Response to Submissions

Section 4.55(1A) Modification – Approved signage at the Overseas Passenger Terminal (Tenancy 5) at Circular Quay West in The Rocks (SSD 7683 MOD 1)

Response to City of Sydney Council's submission on SSD 7683 MOD 1

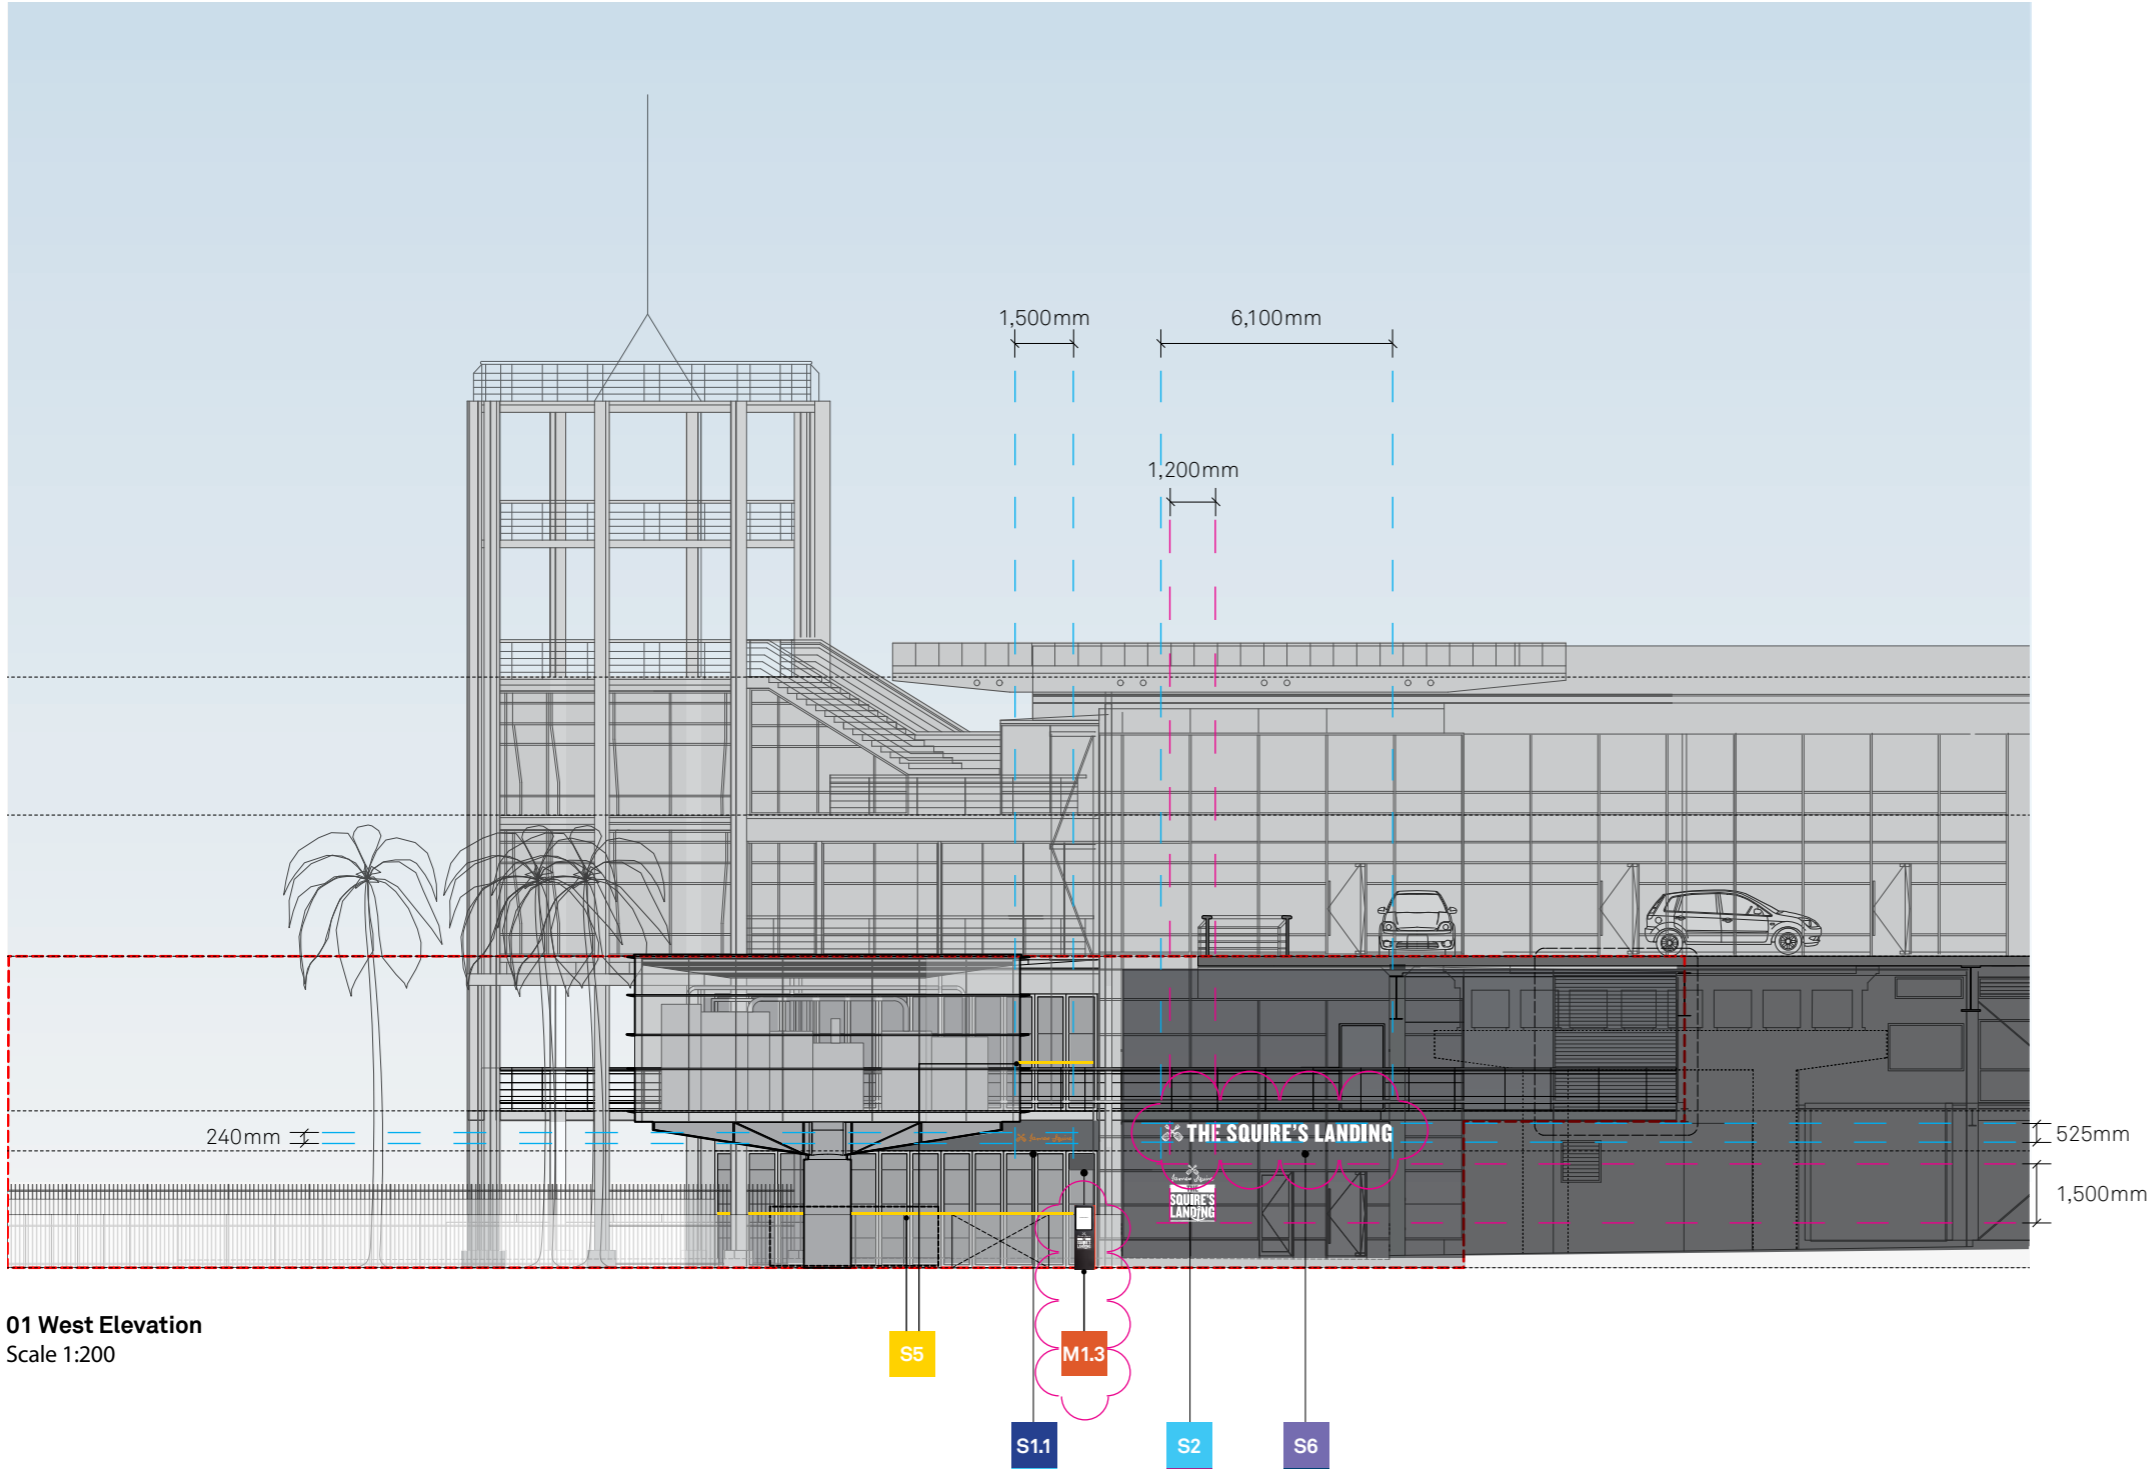
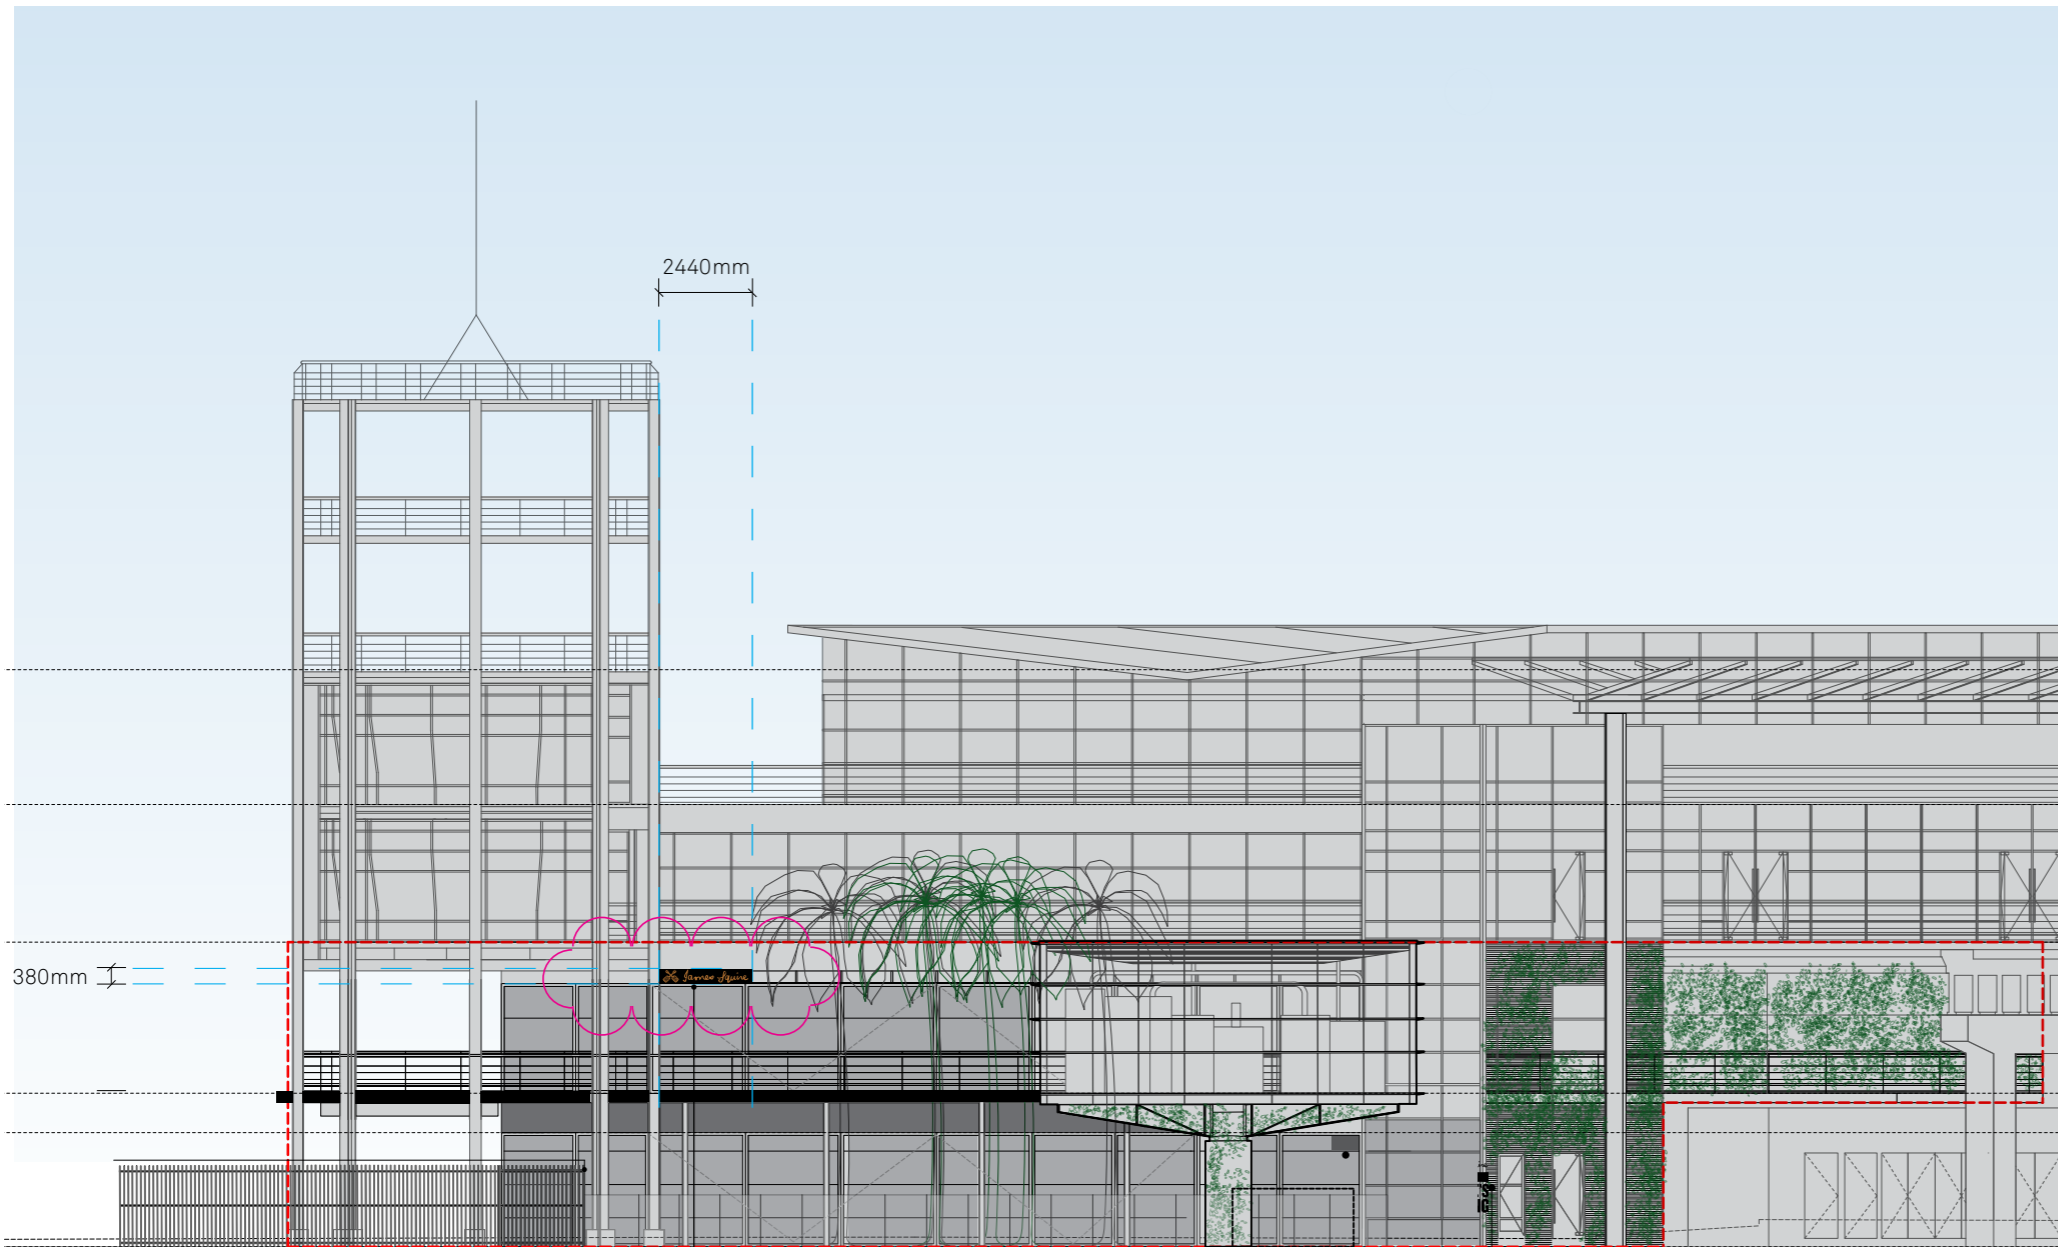
<p>Signs 'S6' and 'S3.2' should be further described and assessed within the Applicant's Statement of Environmental Effects in terms of their compatibility with the surrounding locality.</p>	<p>Sign 'S6' and 'S3.2' are described at Section 3 of the Statement of Environmental Effects (SEE).</p> <p>To re-iterate, sign 'S6' is a proposed new business identification sign (with illuminated channel letters) that is to be positioned on the underside of the Level 2 balcony (directly above the western entrance of the building). The location of sign 'S6' is shown on Page 2 of the Plans Proposed to be Modified (Appendix 3 of the SEE). A photomontage of the proposed sign, as viewed from the western elevation, is shown on Page 5 of Appendix 3.</p> <p>Sign 'S3.2' involves the relocation of an approved business identification sign from the Level 1 to Level 2 awning. The sign is now proposed to be illuminated (halo lit) and increased in size from 1,285 mm x 220 mm to 2,440 mm x 380 mm.</p>

Issue raised	Response
	<p>Section 5 of the SEE provides an assessment of the modification application against the criteria of SEPP 64 including consideration of the signage compatibility with the surrounding locality. The assessment concludes that the modification complies with the provisions of SEPP 64 and will not result in any adverse visual or environmental impacts. Further, the surrounding locality is a recognised tourist and dining precinct where business identification signs are not incompatible with the surrounding area.</p>
